Case Officer: Laura Bell

Applicant: Albion Land

Proposal: 1) Reconfigure the external layout of Unit 5; 2) Elevational changes to Unit 5; 3) Change the roof plan of Unit 5; 4) Elevational changes to Unit 6; 5) Change the roof plan of Unit 6; 6) Repositioning of Personnel Door of Unit 6 (proposed as non-material amendments to 22/01632/REM)

Drawing Title: UNIT 5 FLOOR PLANS

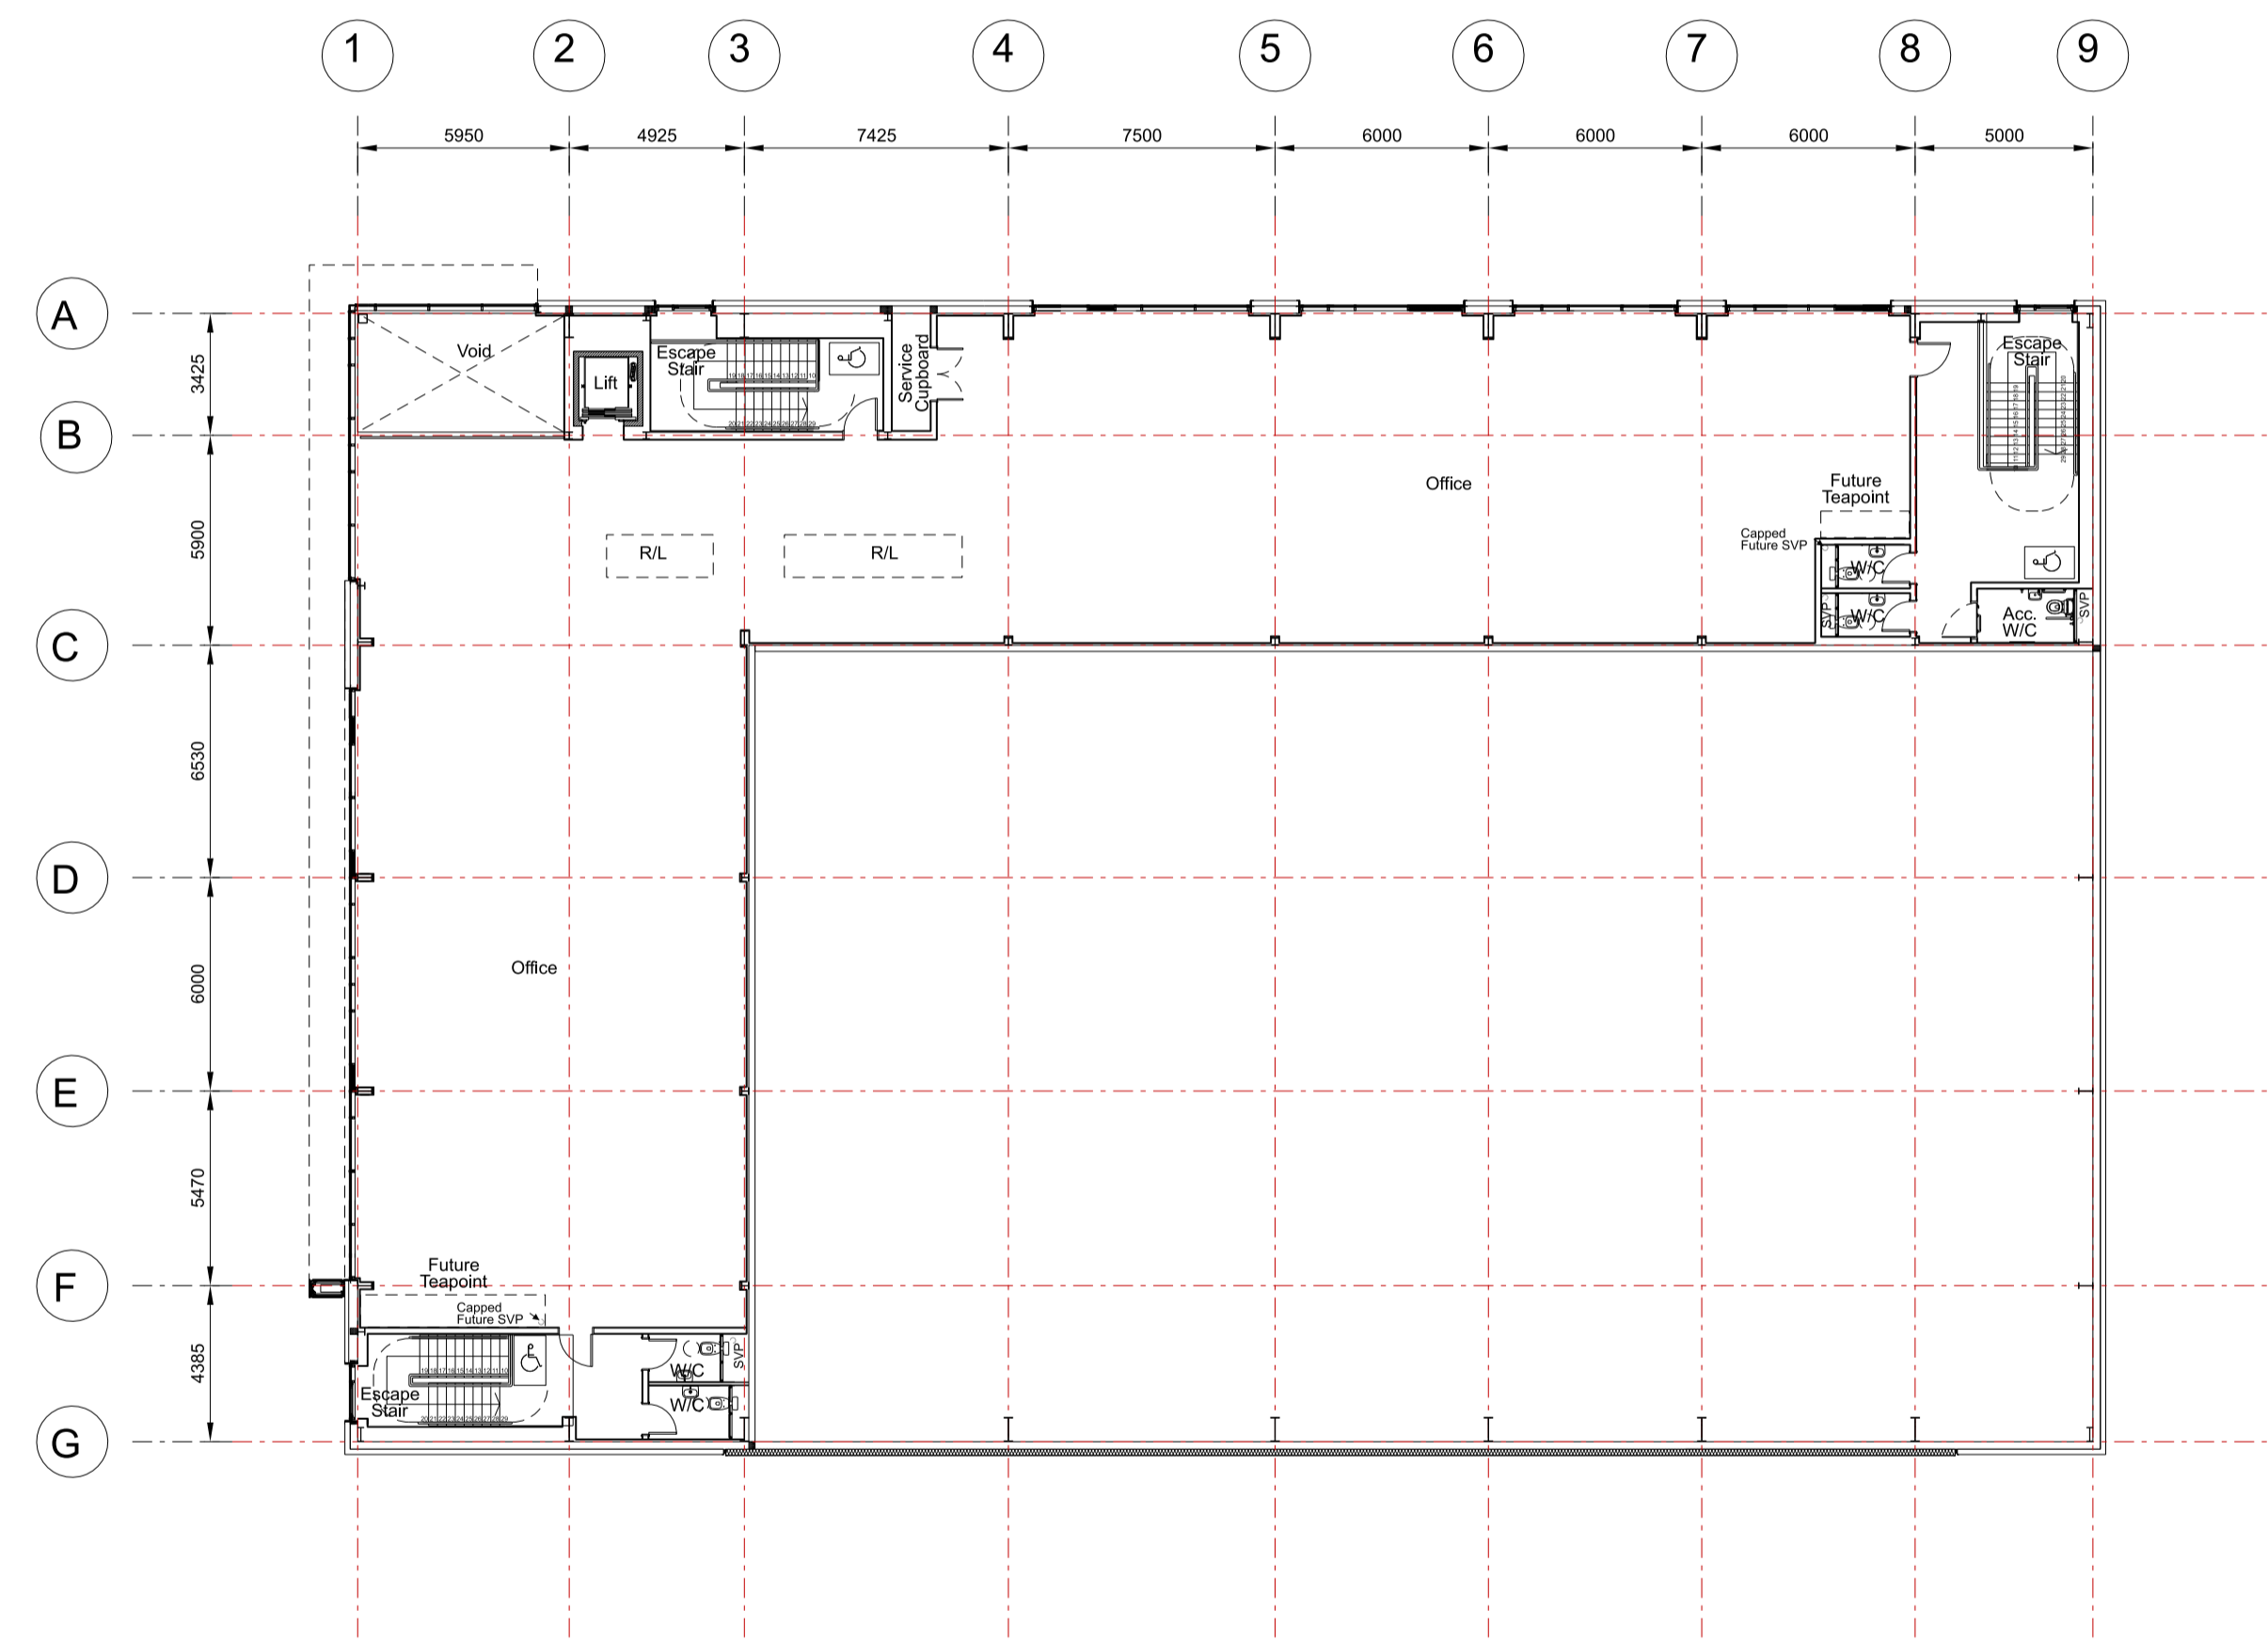
- 5.5. Elevational changes to unit 5 – The applicant states that the changes are in response to the requirements of the secured occupier of the site. Roller shutters have been relocated on the south east elevation, by spacing them further apart on the elevation, with the addition of an overnight delivery door. A sliding double door is also proposed on the south west elevation. Materials remain consistent with the style, form and character of the wider site. The changes are being sought by varying condition 1 to update the approved Entrance Canopy Details, Floor Plans and Elevations for Unit 5.

Drawing Title:
UNIT 6 ELEVATIONS

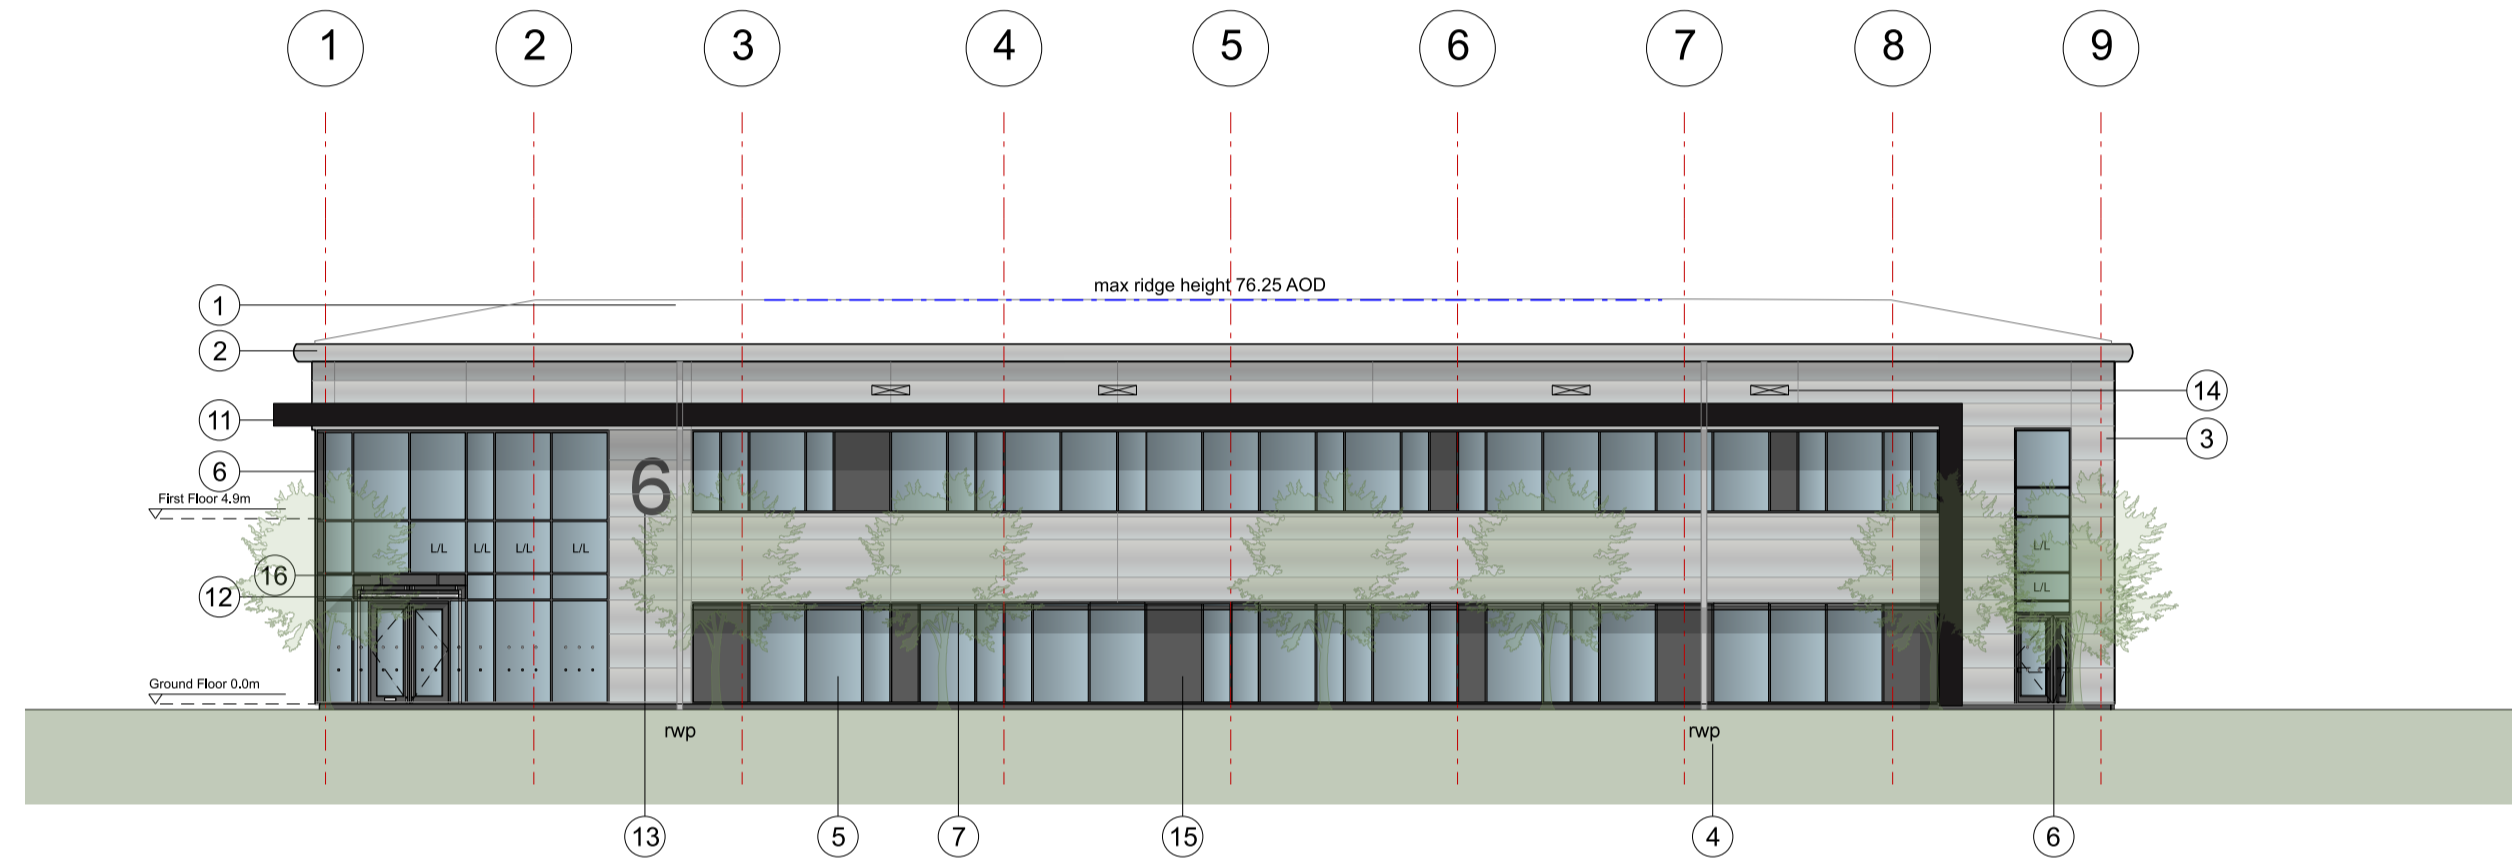
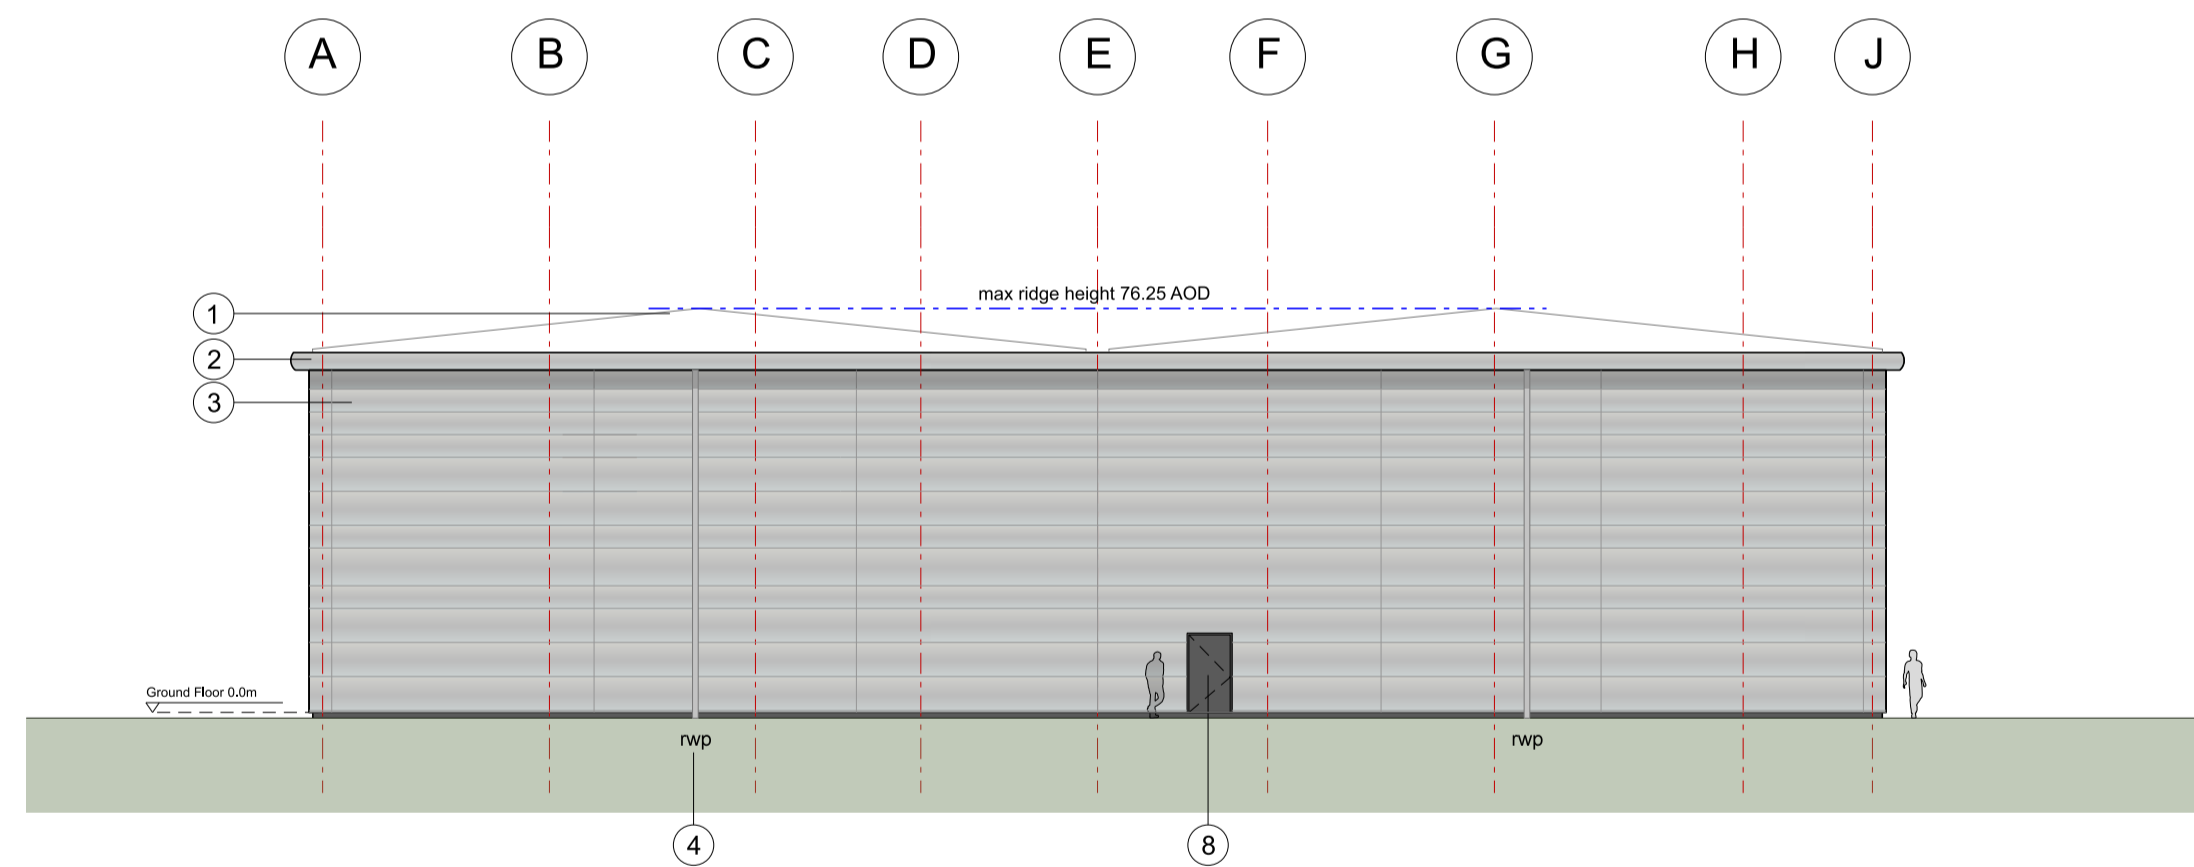
- 5.8. Elevation changes to unit 6 – very minor shift of the service door on the south east elevation and minor changes to the external design, including the mullion centres above the entrance door and casement openings.
